Stephen Kilmartin
Planning
Ribbles Valley Borough Council

Email: ecology@lancashire.gov.uk
Your ref: CONECO/3/2013/0854
Our ref: 03/13/0584/ASM/ASP/RS
Date: 6th January 2014

Ecological comments

Planning Application No: **3/2013/0854**
Proposals: **Erection of replacement dwelling**
Location: **Sawley Lodge**
District: **Ribble Valley**

SCALE: 1:500@A1  
REV: /  
DRAWING NO: 836-01  
DRAWN BY: EP  
CHECKED BY: EH  
DATE: 13.08.13

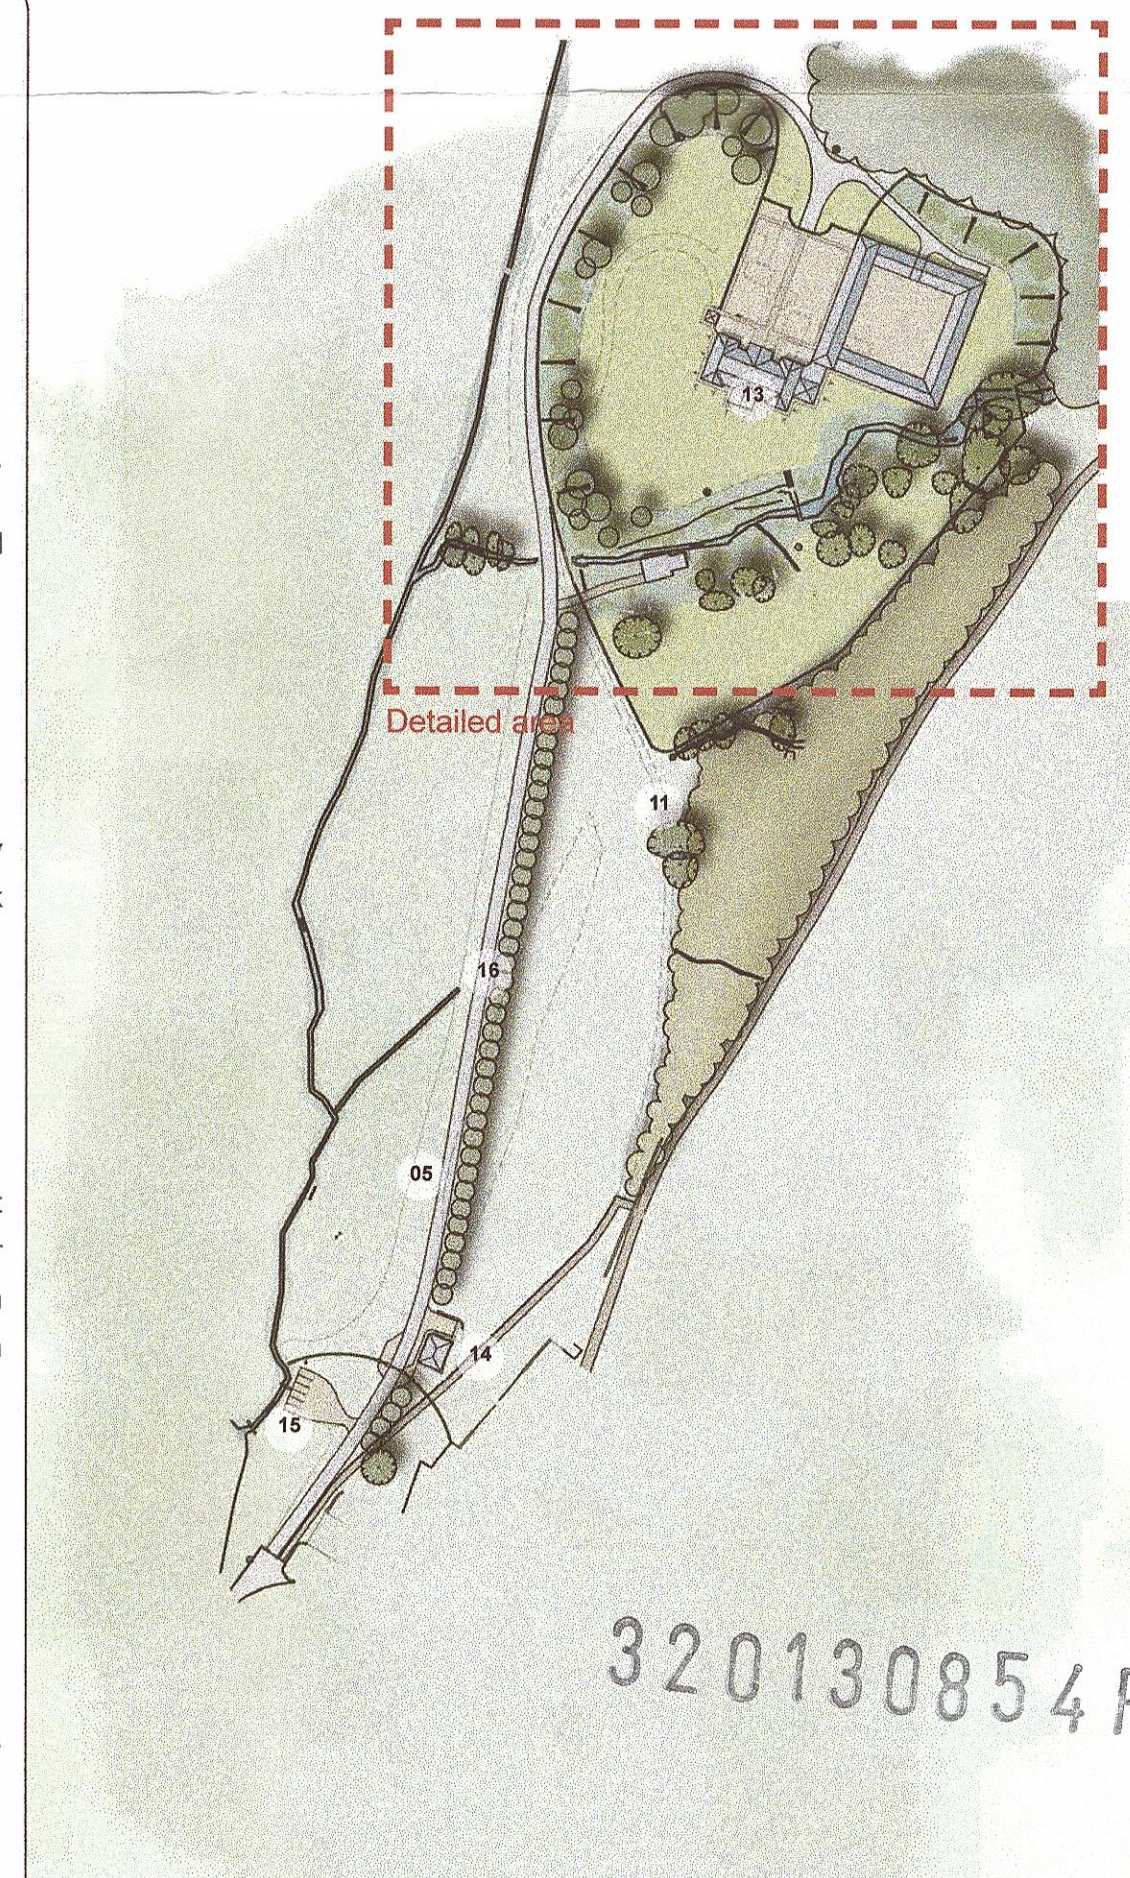
The proposals do not appear to have been designed to avoid impacts. The proposals would affect an ancient woodland site (discussed above) and numerous trees are proposed for removal including mature specimens, although it is not clear to me what landscaping proposals and tree works form part of this application.

It is not clear to me that the proposed impacts on trees are necessary and/or unavoidable as many trees appear to be proposed for removal for "landscaping" purposes and due to them having "defects", including mature and numerous early mature native specimens. The defects (dead wood, cavities etc) will provide value to biodiversity (fungi, birds, invertebrates, bats etc) and impacts on these trees will result in a loss of biodiversity. If these works do not form part of this application then the applicant should be aware that trees have potential to support nesting birds and roosting bats and should therefore be aware of the legal protection afforded to bats and birds when planning any tree works.

Map 1 - 1:1096 Ordnance Survey base plan of Sawley Lodge. Roost buildings are coloured orange and the proposed bat building is coloured black.

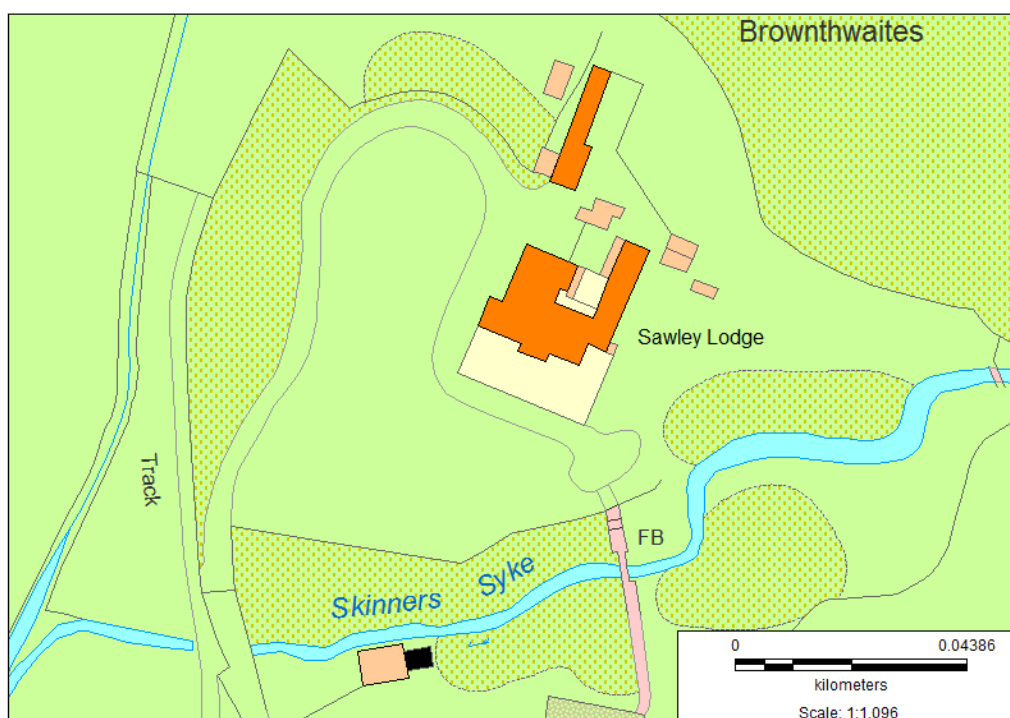
A mitigation method statement has been submitted to address the 3rd test. Although I am not able to comment on these proposals at this stage as the survey work is not yet complete, I note that the proposals involve refurbishment of an existing building and there does not appear be any information regarding the current use of the building by bats and birds. Surveys to establish the use by bats and birds (barn owls and nesting birds) of any existing building proposed to be used as mitigation would need to be submitted prior to determination of the application.
